Mr Saul Moran
Development Manager
ARNCLIFFE EDEN PROPERTY PTY LTD
173 SUSSEX STREET
SYDNEY NSW 2000

27/04/2022

Eden Street, Arncliffe Mixed Use Redevelopment (SSD-11429726)
Request for additional information

NOTE * RFI RESPONSE:
GFA ERRORS UPDATED

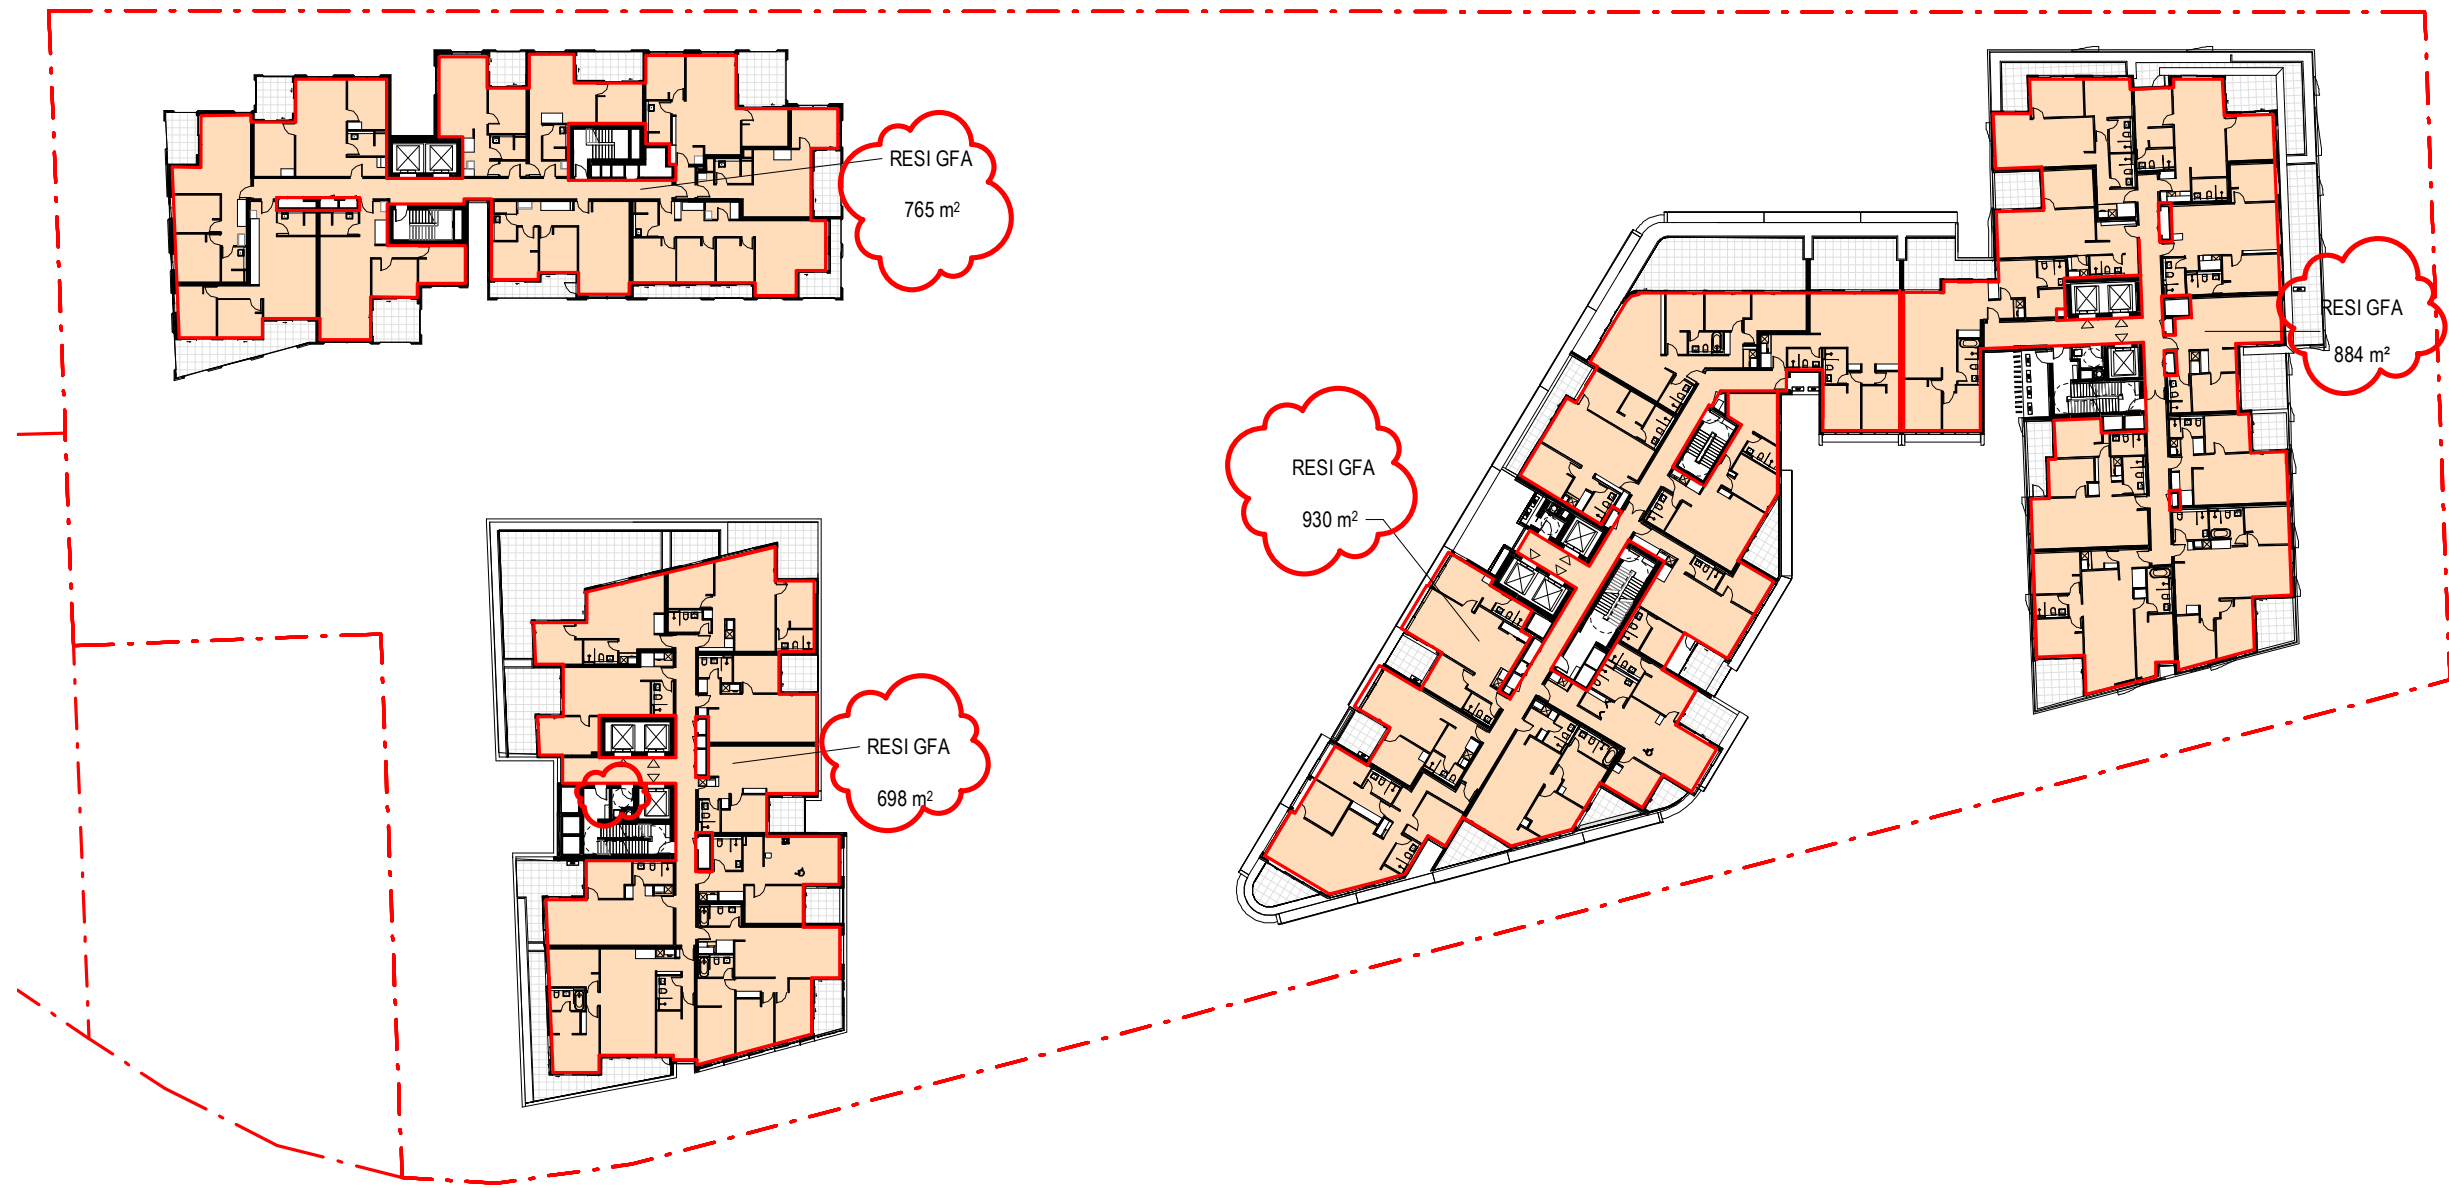
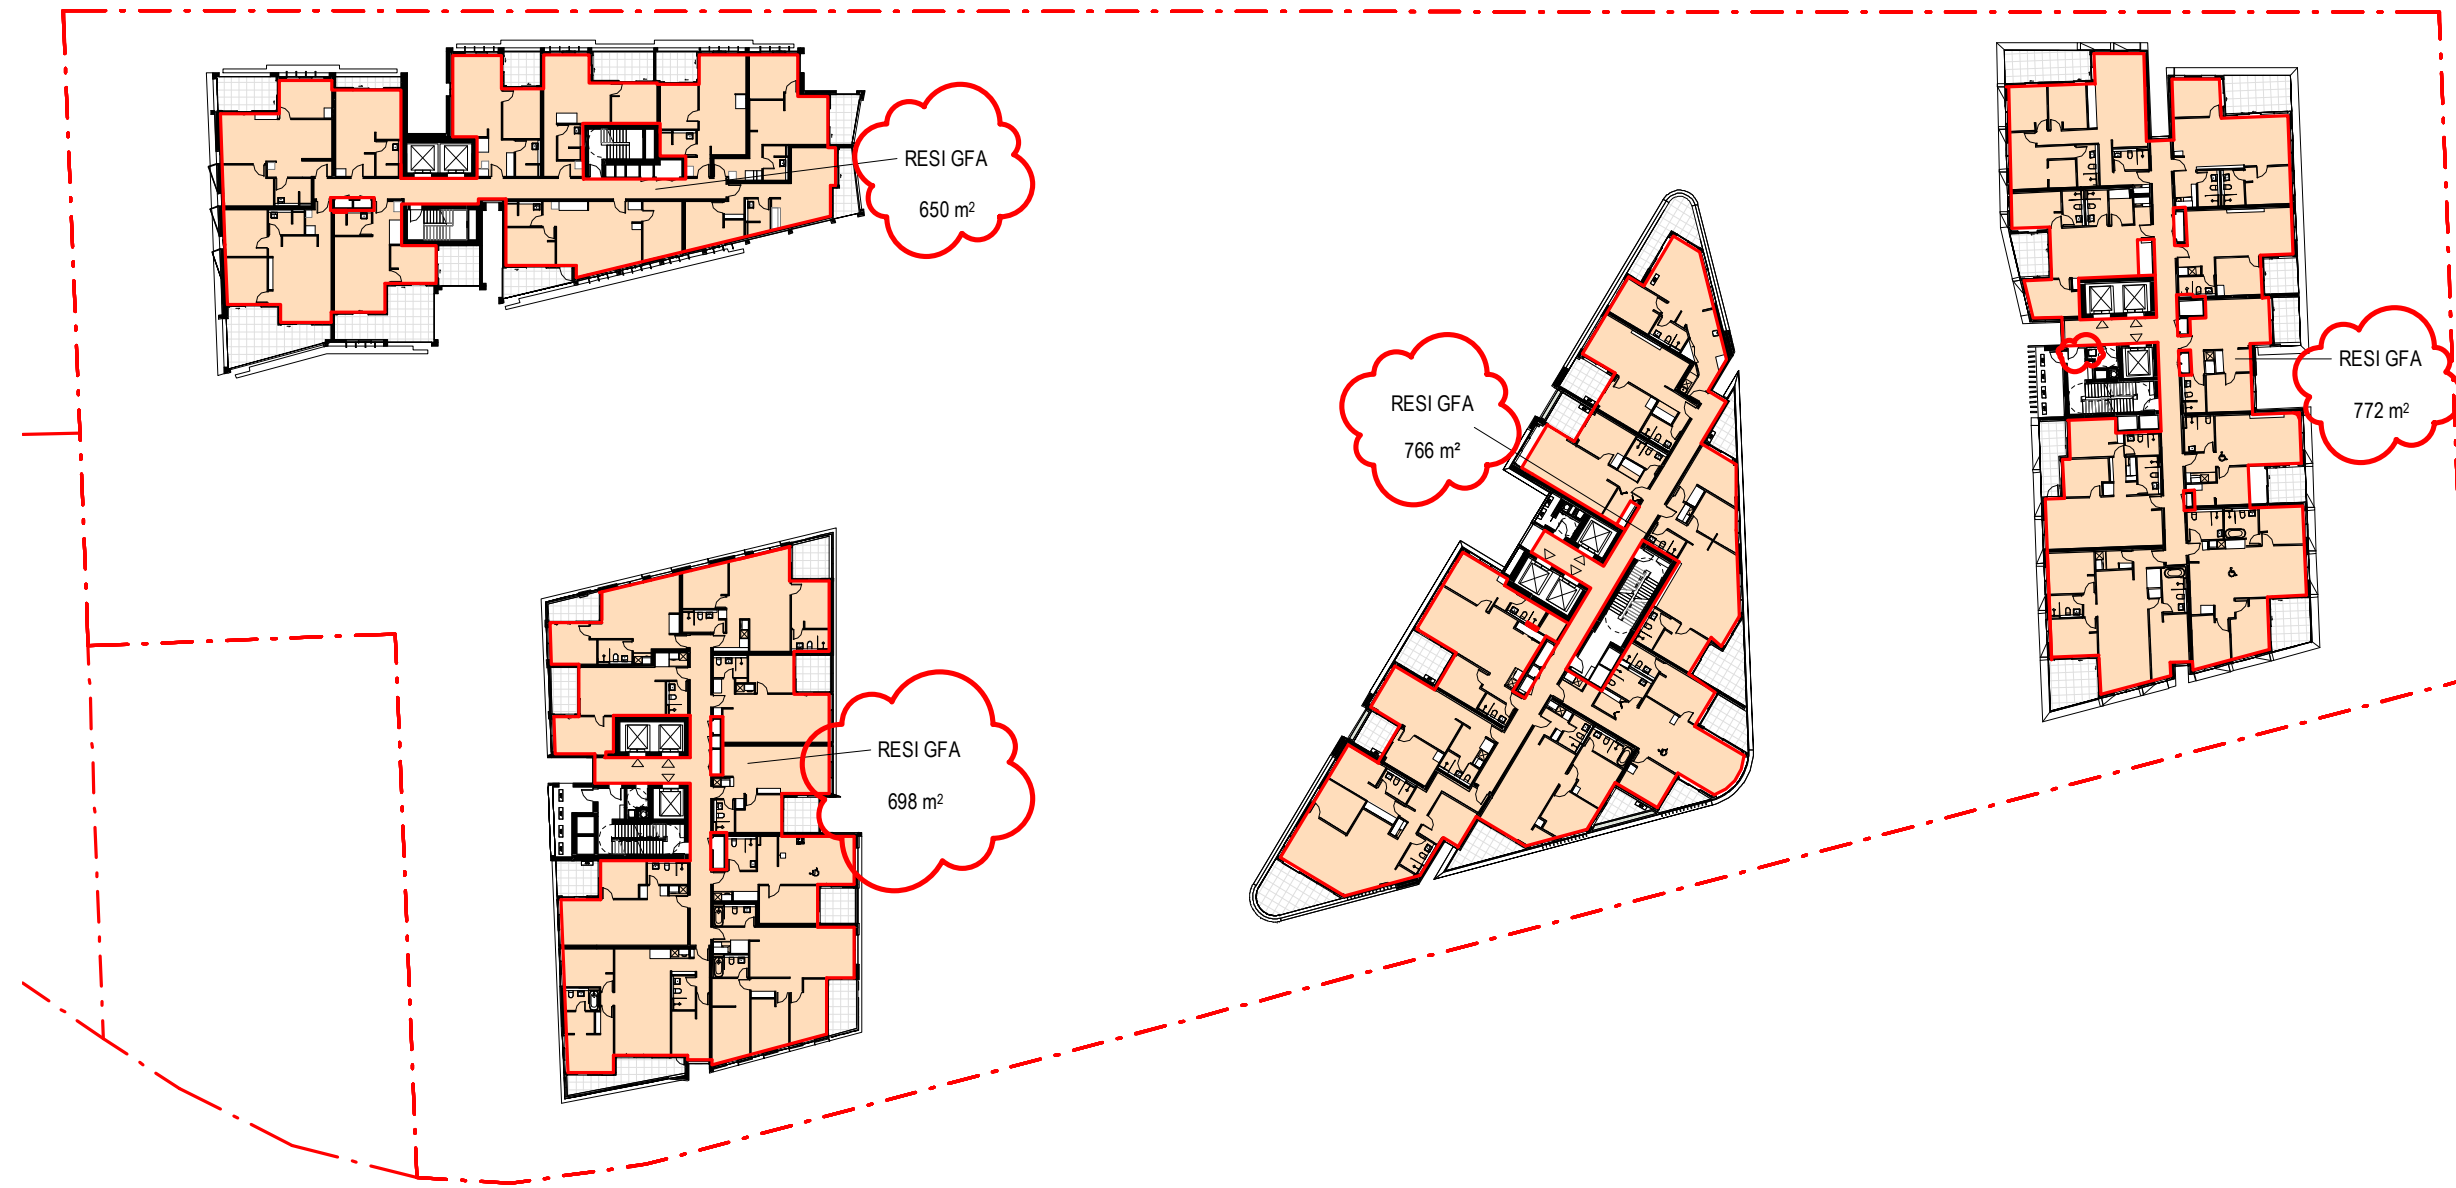
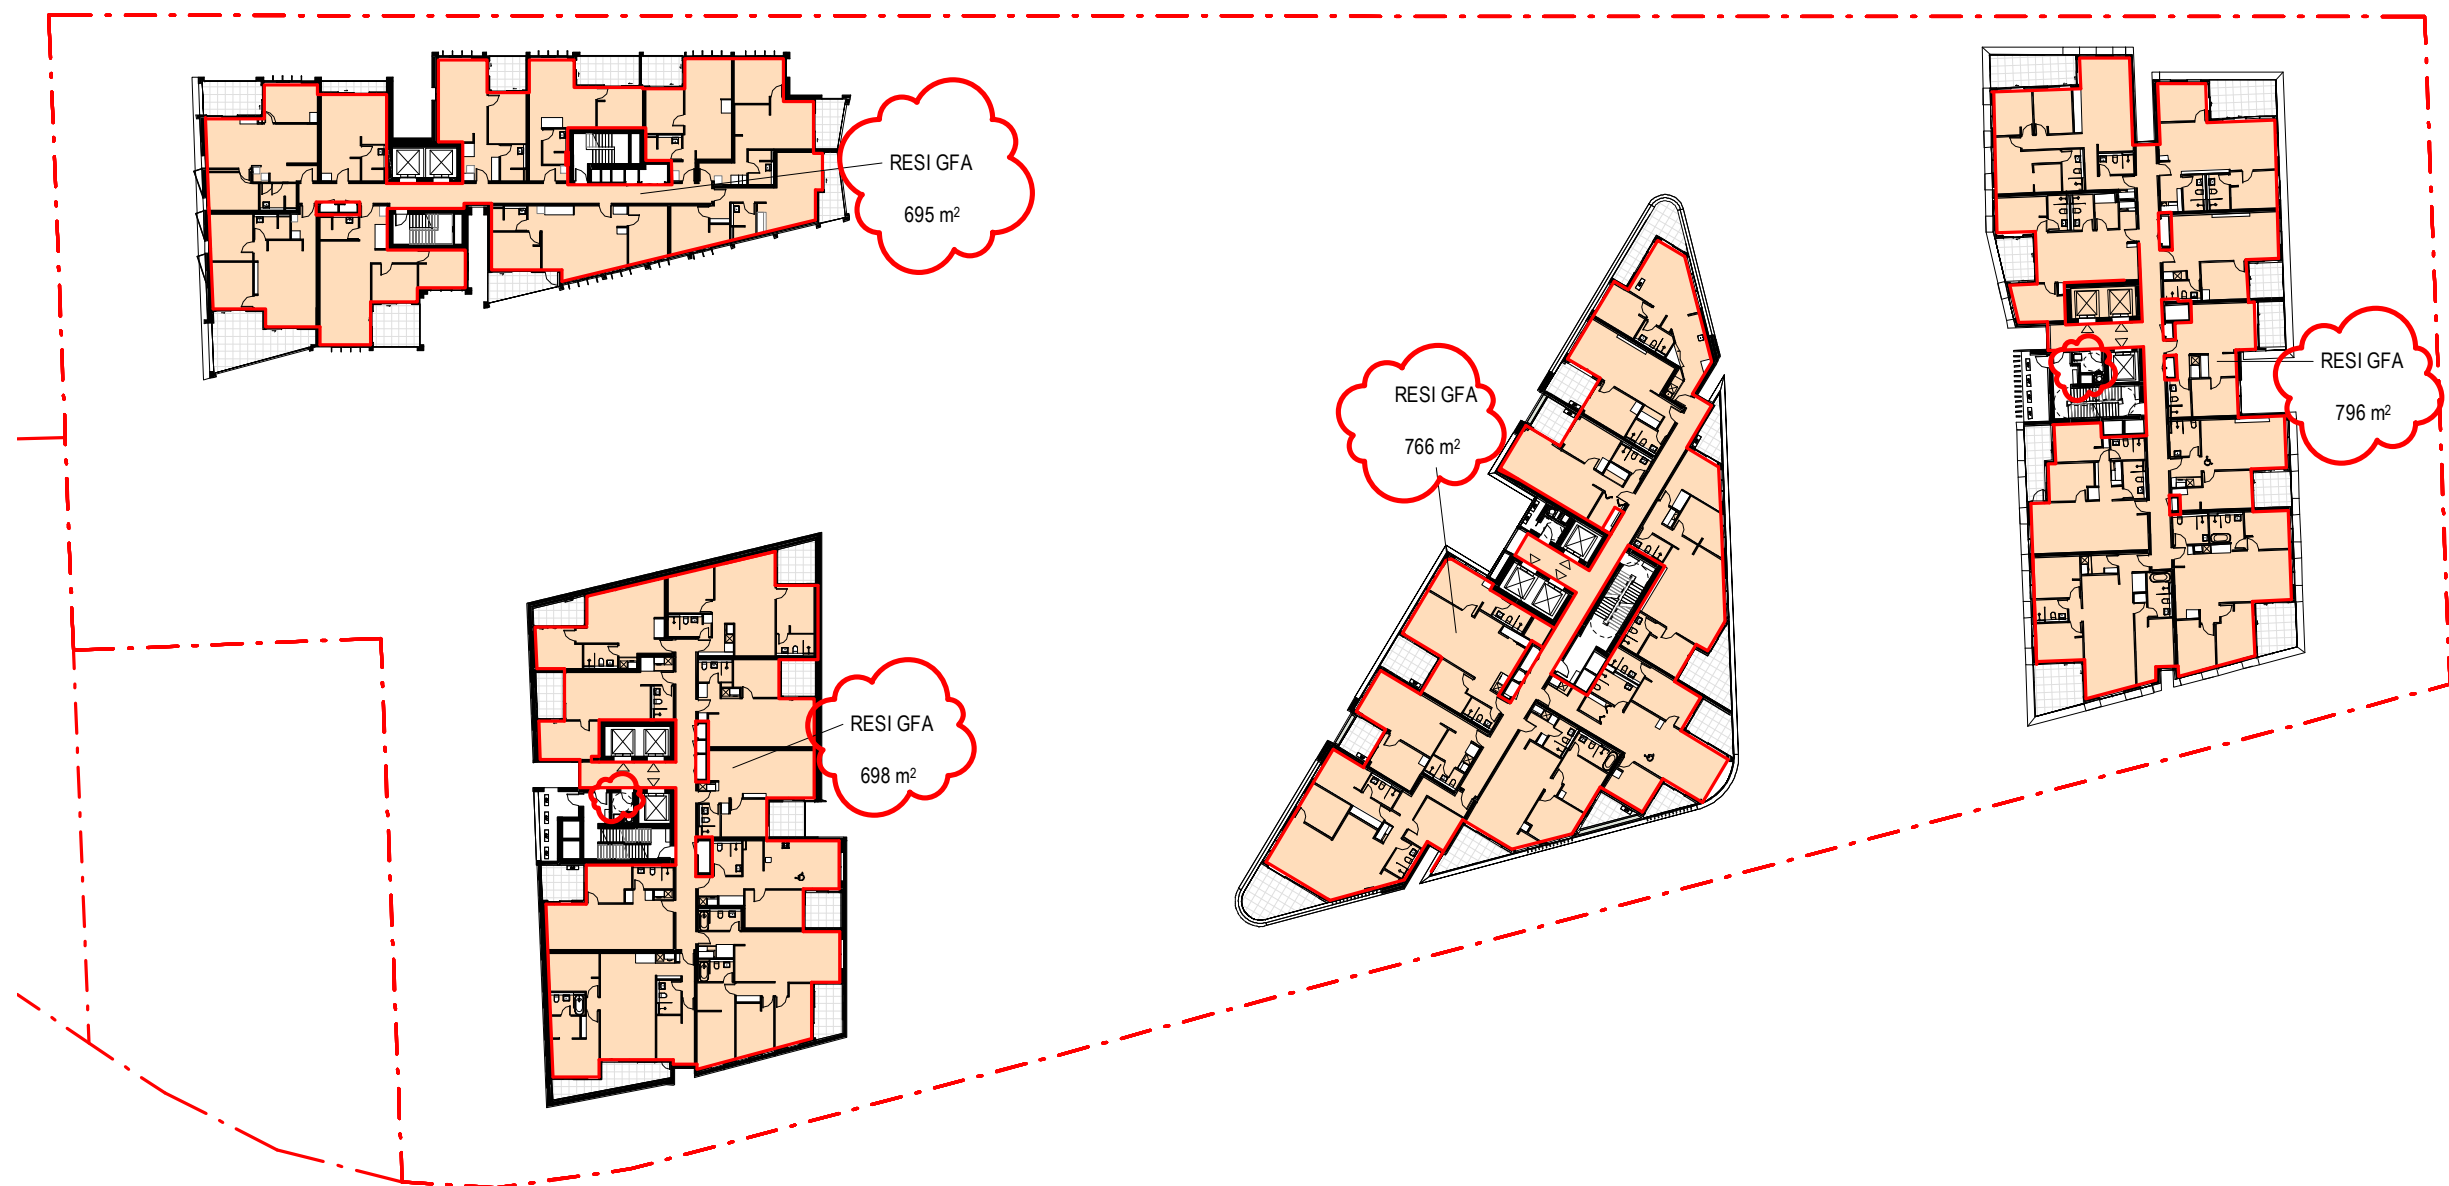
- An updated 4.6 variation request accurately reflecting the proposed GFA.
- Clarification and further justification for the proposed 850mm boundary setback to the neighbouring properties at 52 Eden Street, 7 Forest Road and 181 Princes Highway. I note that the wall adjacent to this boundary is not a party wall and the justification that it ensures no constructability or structural concerns for future development is unclear. Consideration should also be given to how the wall itself and the area between the building and the boundary would be treated, accessed and maintained.
- Confirmation on the plans sought for approval including a full consolidated set of architectural, landscape and any other plans reflecting the proposal as amended by the RtS and Responses to the Department's RFIs.
